53 Hume Street,
Crows Nest,
Sydney,
NSW

Application SSD-614000212 RFI Landscape Response

This formal response pertains to application SSD-614000212, Crows Nest Over Station development Site B and has been requested by the Department of Planning, Housing and Infrastructure (DPHI) as required under section 59(2) of the *Environmental Planning and Assessment Regulation 2021* to answer issues relating to the landscape architectural scope items raised in the relevant submissions. These issues are also outlined in Attachment A of the formal request for response letter sent by DPHI on the 19th September, 2025. RPS' comments are outlined below in Green and directly reference response letter produced by the Structural Engineer (Robert Bird Group):

Sheet title  
CARPARK LEVEL 05

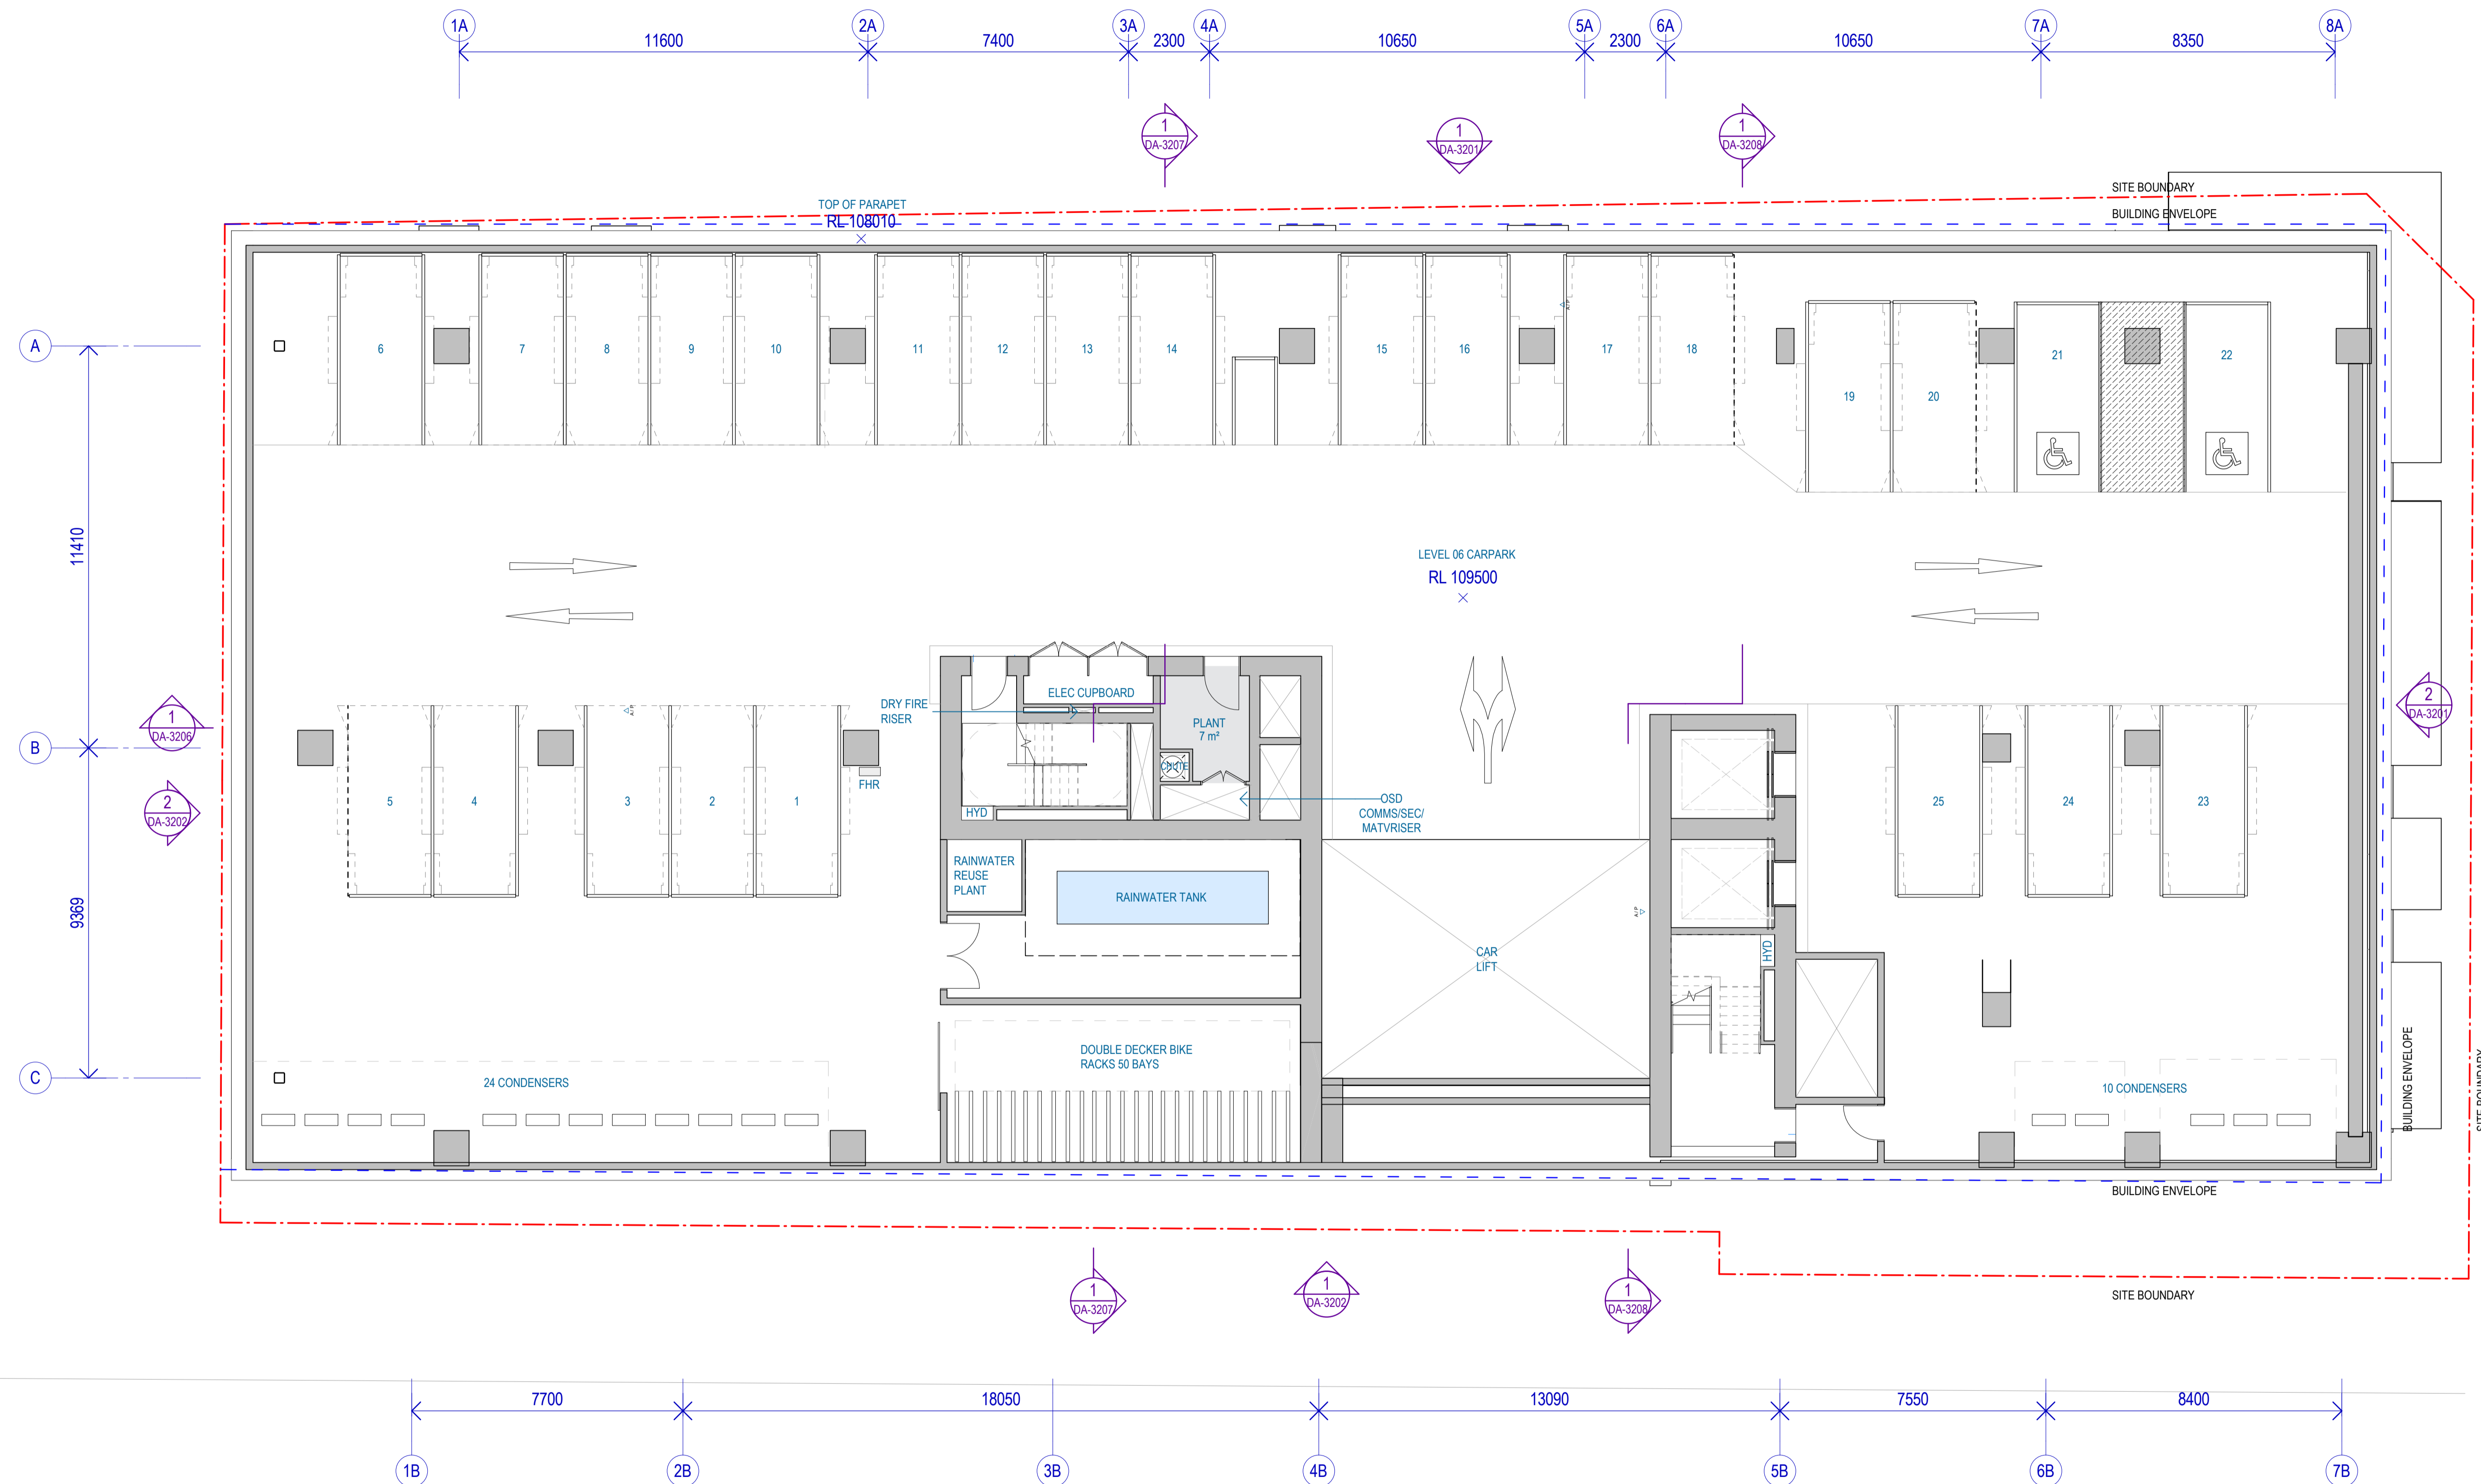
- a. Review and revise the façade treatments of the car parking levels to provide an appropriate horizontal height datum/ delineation between the station and the development (as recommended by the Design Guidelines) and to reduce its visual impacts. This may include consideration of:
 - i. Additional landscaping along the car parking level and provide details to demonstrate any landscaping would be practical and viable

Landscaping has been thoroughly interrogated across the extent of the podium through several building design iterations to ensure maximum possible landscape amenity is provided at the largest appropriate size; however as noted by the structural engineer in their response report, the ability for the built form to accommodate landscaping around the podium skirt is restricted by structural column and slab requirements.

With reference to the structural engineer's response report, landscaping can be maintained along three of the four facades with only planting to the Hume Street façade being omitted due to the introduction of a structural transfer slab removing planting opportunities.

Façade planting to the balance of the podium skirt will have more than ample soil depth at approx. 1500mm deep with a 1000mm air gap above the soil FFL to allow for medium to large cascading stock to be installed; This allows for the maximum immediate vegetation screening possible. Refer Figure 1-1 for a section view of a typical façade planter.

RPS is determined to ensure a level of landscaping amenity around the perimeter of the carpark level that aligns with previously circulated 3D renders endorsed by the assessing body and accepts the Structural Engineering suggestion to maintain landscaping along the Pacific Highway façade of Level 05.
